16 May, 2014

Your ref: MP10_0046 Mod 2

**Environmental Assessment
Russell Vale Colliery – Underground
Modified Preliminary Project (MP 10_0046 Mod 2)**

Figure 14 details the known structures in the Bulli Seam for the Wonga East Study Area. These structures have been derived from detailed examination of available mine plans. Each structure is annotated for easy reference and discussed in the following sections on faulting and igneous intrusions.

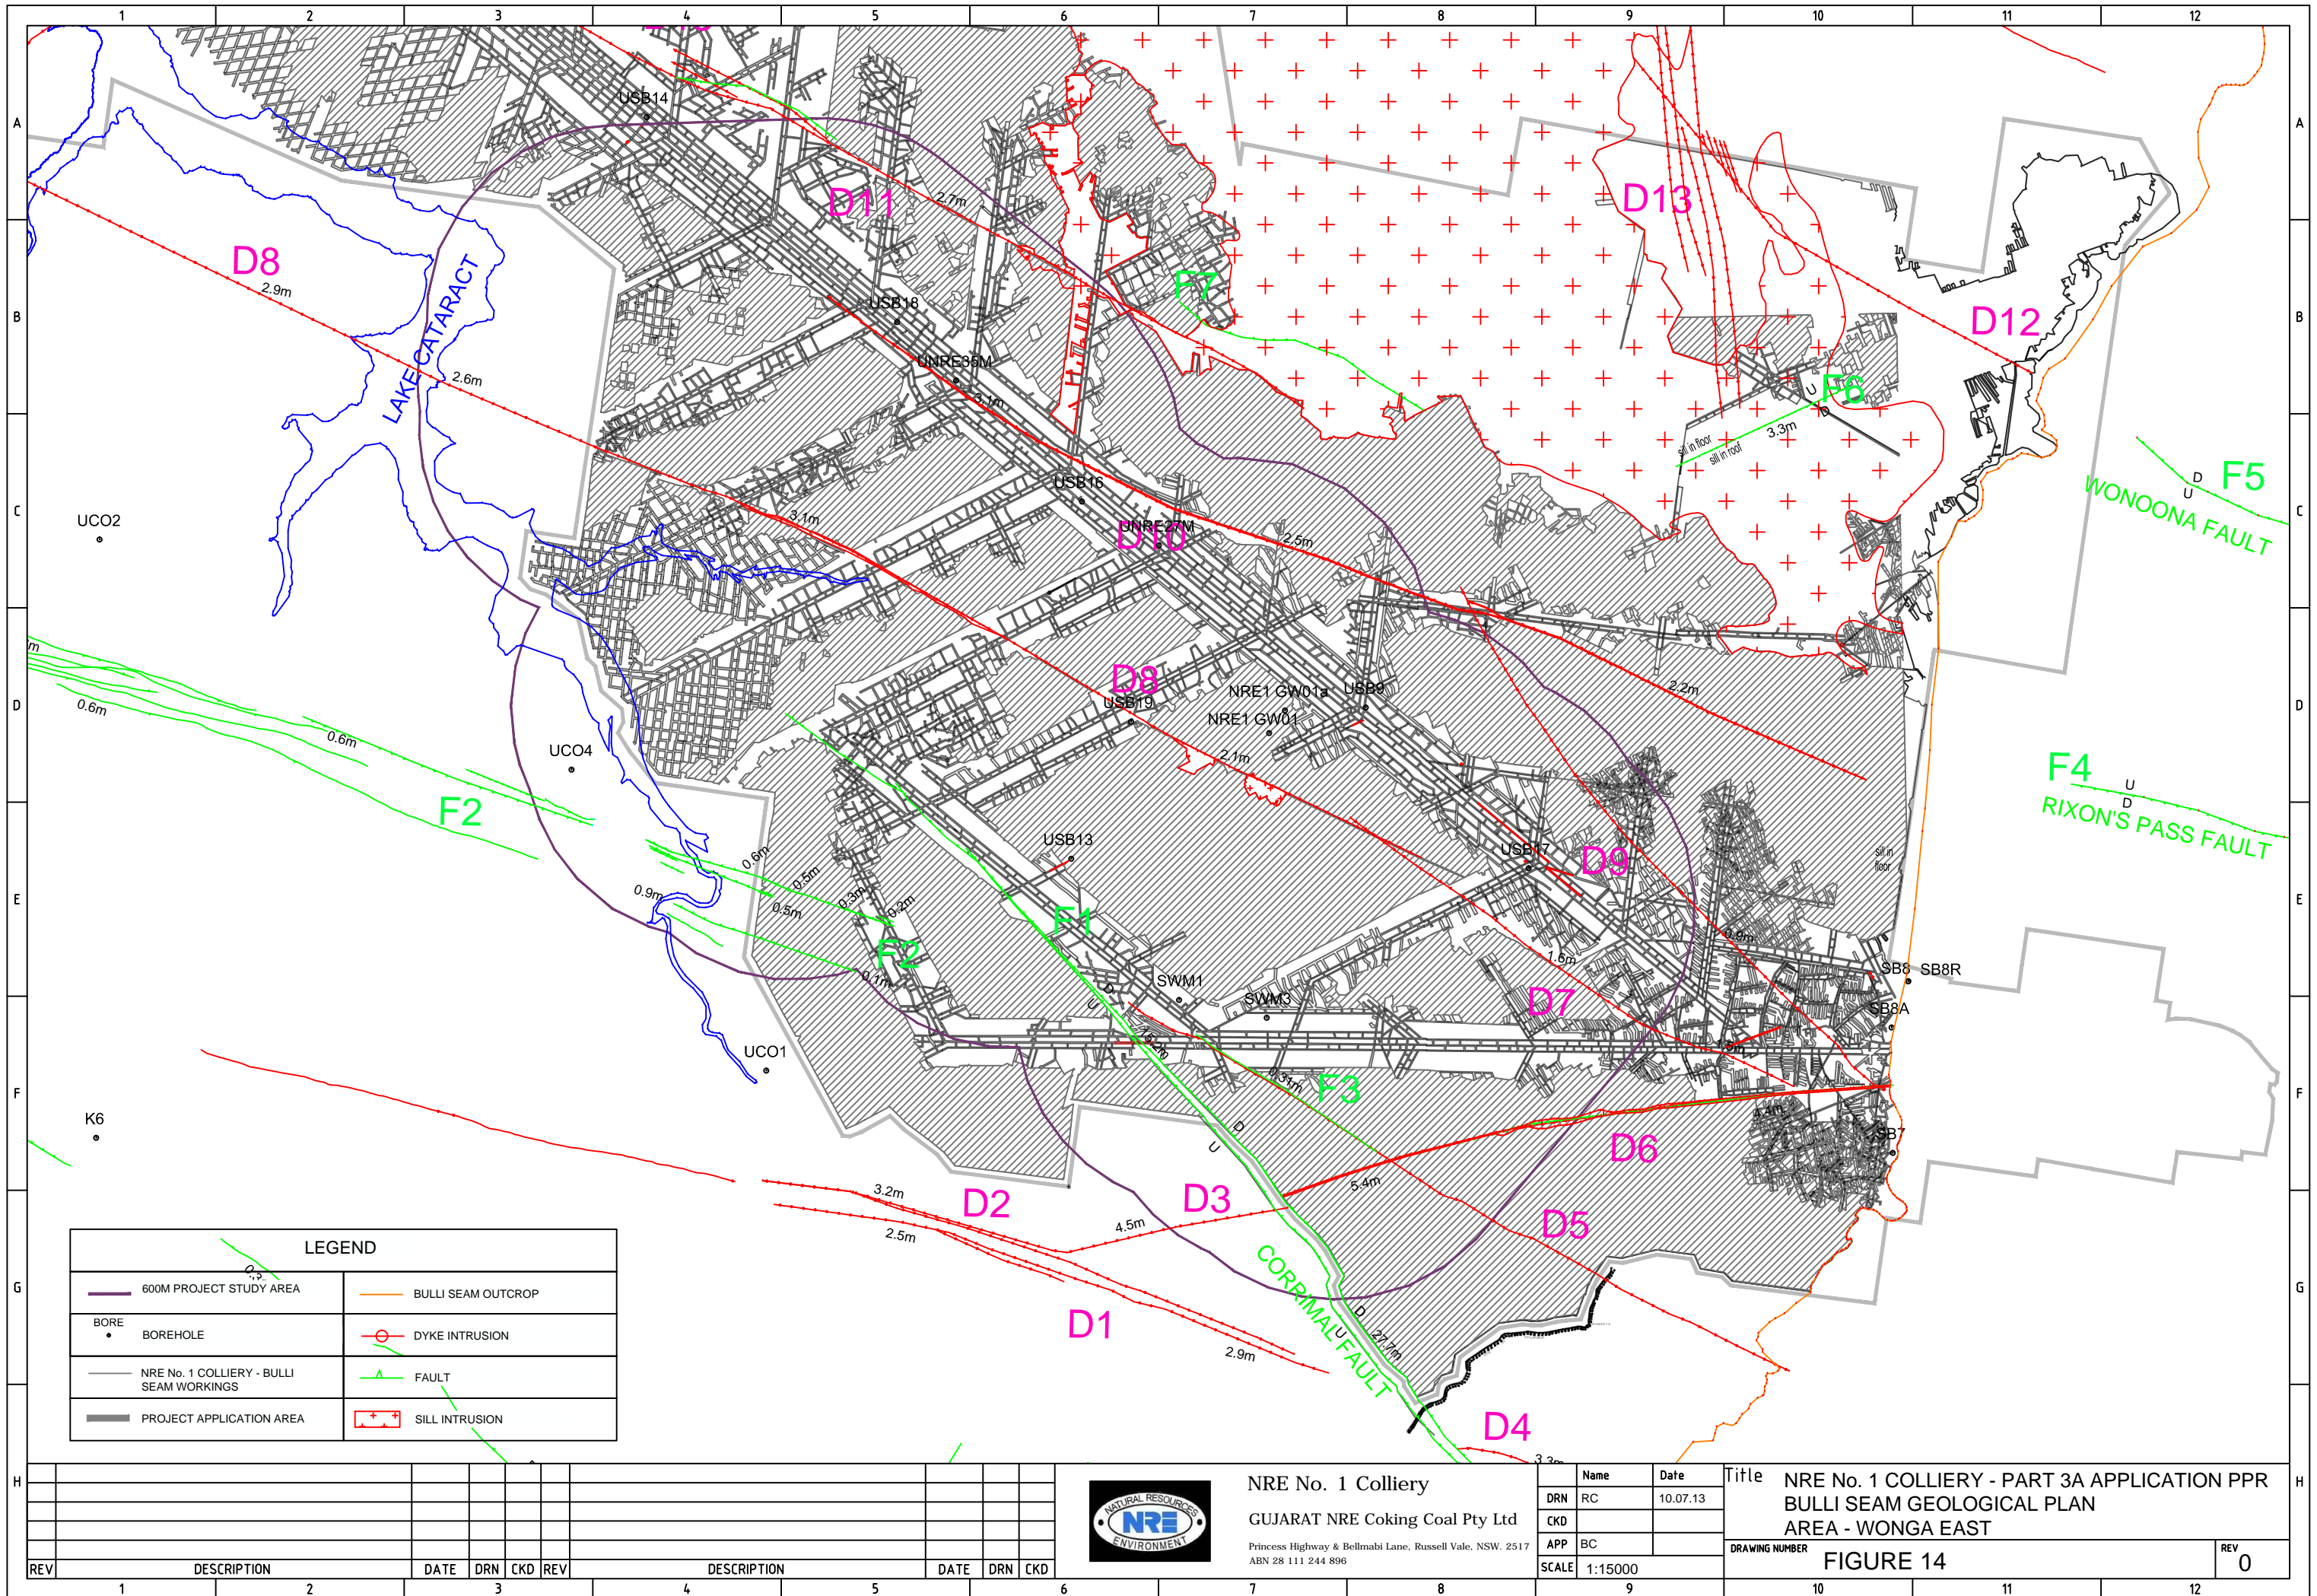
- The Corrimal Fault has been intersected by LW6 gateroads and the fault does not appear to be petering out
- In this area a dyke D8 crosses the area. It is present in the workings and exposed in the sides of the Reservoir.

An inspection of the plan that shows Bulli seam workings around the junction of Cataract Creek and Cataract River in the adjoining Corrimal Colliery, indicates workings are absent between the projections of the dyke (D8) and Corrimal Fault in the neighbouring Corrimal Colliery. The absence of workings in this area is supportive of there being more than a reasonable probability that the Corrimal Fault exists in the area. That is, the evidence regarding absence or presence of the Fault is contradictory. A statement that indications that Bulli Seam workings have not intersected the Fault is not sufficient justification to claim that the Fault is not present.

Assuming the fault is present and projecting the fault to the surface (ie offset 200m to the south west from trace on Bulli seam), results in the surface expression aligned with the Reservoir.

Longwall 6 maingate and tailgate roadways have both intersected the Corrimal Fault with throws of over 1m. The fault is present in the area to be extracted by the first 400m of LW6.

The proposed first 400m of LW6 extracts through the zone of the Corrimal Fault. In TG6 the development intersected 3 faults (between 12c/t and 13c/t) which had total throws of approximately 1.8m upthrown to the SW. In MG6, three faults have been intersected so far (development not completed). One is upthrown by 0.93m another downthrown by 0.55m and the third is upthrown by 0.48m.

No assessment of the height of connective fracturing through this zone is presented. Adding to the uncertainty about the height of connective fracturing is the presence of Bulli Seam goaf on the SW of the fault zone.

A borehole between LW6 and the Reservoir that investigates/monitors the Bulgo Sandstone needs to be in place before LW6 extraction commences.
